Appeal Decision

Appeal Ref: APP/T2350/D/18/3212869

The Tithe Barn, Station Road, Rimington BB7 4DR

- The appeal is made under section 78 of the Town and Country Planning Act 1990 against a refusal to grant planning permission.
 - The appeal is made by Mr Woolfall against the decision of Ribble Valley Borough Council.
 - The application Ref 3/2018/0480, dated 16 May 2018, was refused by notice dated 15 August 2018.
 - The development proposed is change of use of agricultural area to allow for the extension of the residential curtilage and first floor extension to the dwelling.
-

PROPOSED EAST ELEVATION TO STATION ROAD

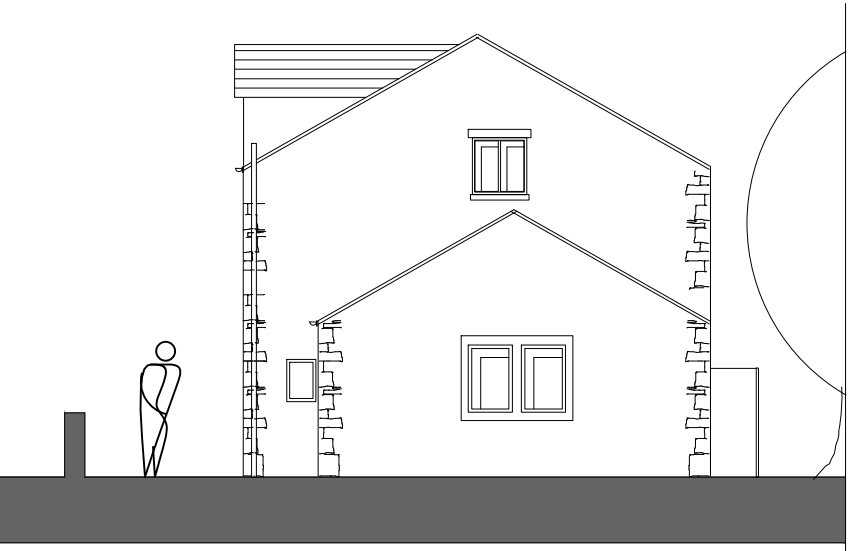
10. By virtue of their additional width and stone mullion design, the windows in the proposed extension would be noticeably different from the windows of the 2 storey dwelling. At first floor level, they would also be noticeably dissimilar from the dormer windows as a result of the different design, shape and relationship to the eaves line and roofscape. The different size and style to both the ground and first floor windows of the original barn conversion would result in a discordant and inconsistent appearance, and the proposed extension would be more prominent as a result of the difference.

11. The proposed extension would be set back from the front elevation, and the height of the ridgeline would be set below that of the original barn. However, the eaves would be noticeably taller than those of the host property and this would result in the appearance of a foreshortened roof and discordant roofscape when viewed from the street. This would be conspicuous and visually obtrusive.

12. Furthermore, the rooflight in the proposed extension would be set centrally above the stone window mullion, in contrast to the rooflight positioning within the existing 2 storey roof which is offset from the windows. It would also be misaligned horizontally with the rooflights in the former barn roof. The mismatch in rooflight position and height would also be discordant.

PROPOSED NORTH ELEVATION A-A
(SECTION THROUGH THE LINK)

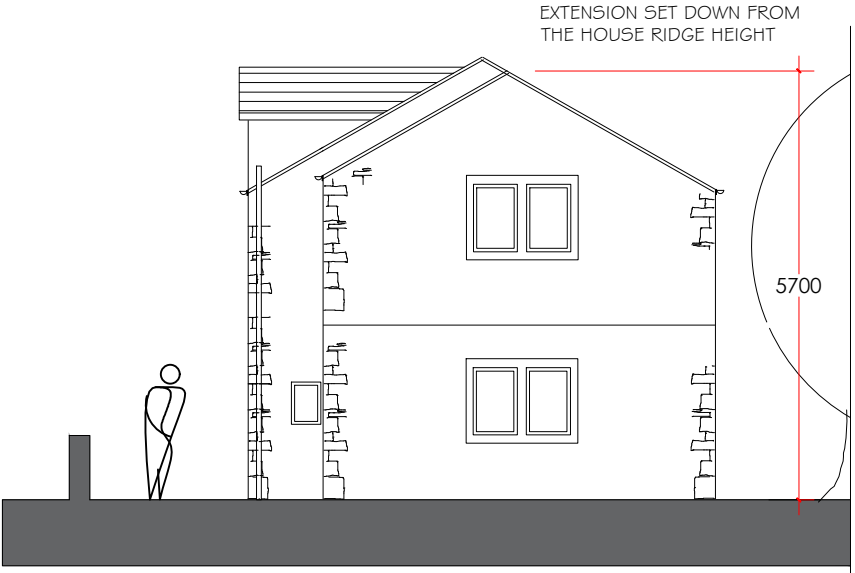
13. The rear elevation of the proposed extension would be flush with the rear of the main property. Notwithstanding the lower ridgeline and set back front elevation, as a result of its substantial width and height, when viewed from the north the proposed gable end would obscure the original 2 storey gable. It would be a prominent addition to the original dwelling that would not be in keeping with the character and appearance of the host property or the street scene.

**PROPOSED SITE PLAN
PHA/HW/20
MAY 2018
1:500 AT A2**

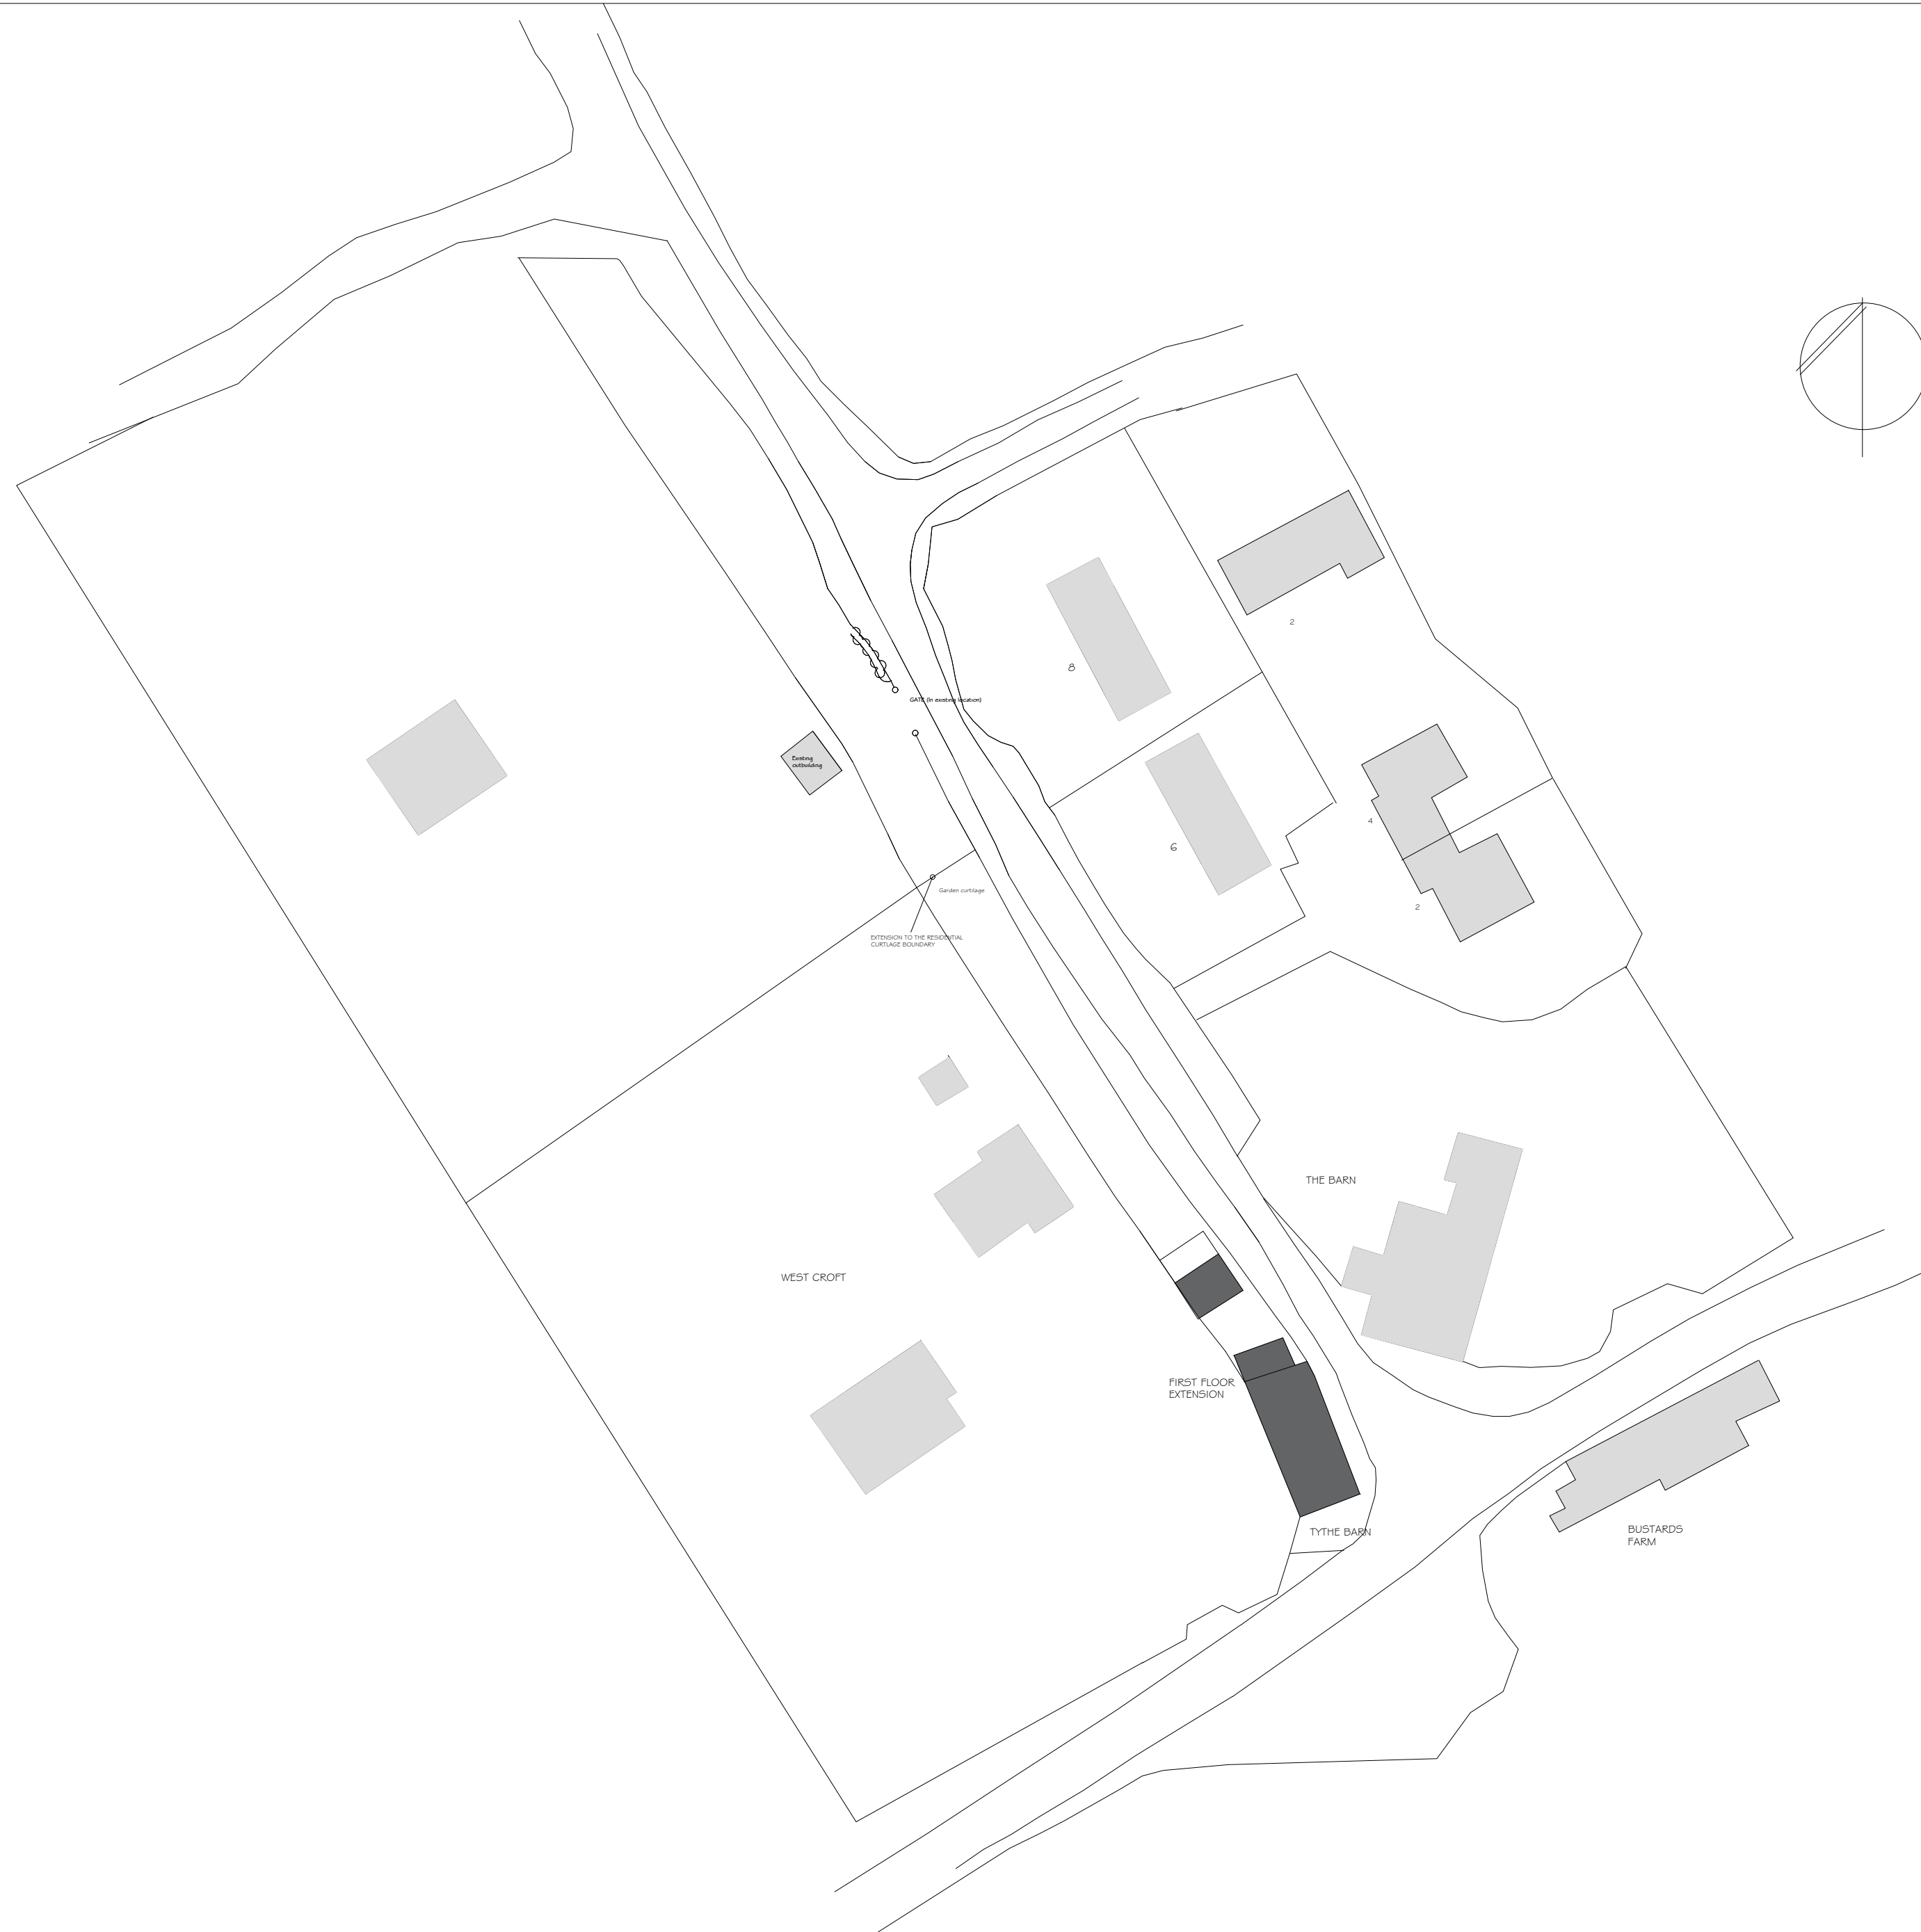
18. The proposed change of use of agricultural land to allow for the extension of the residential curtilage relates to a narrow parcel of land adjacent to Station Road extending beyond the existing garden. The proposed change of use would not result in any harmful effects and is not therefore in conflict with the development plan.

- 1) The development hereby permitted shall begin not later than 3 years from the date of this decision.
 - 2) The development hereby permitted shall be carried out in accordance with the following approved plans: PHA/HW/20 – Proposed Residential Curtilage Extension, dated May 2018.

- 3) Prior to their installation, details of the alignment, height and appearance of all boundary treatments, fencing and walling to be erected shall be submitted to and approved in writing by the local planning authority. Development shall be carried out in accordance with the approved details.
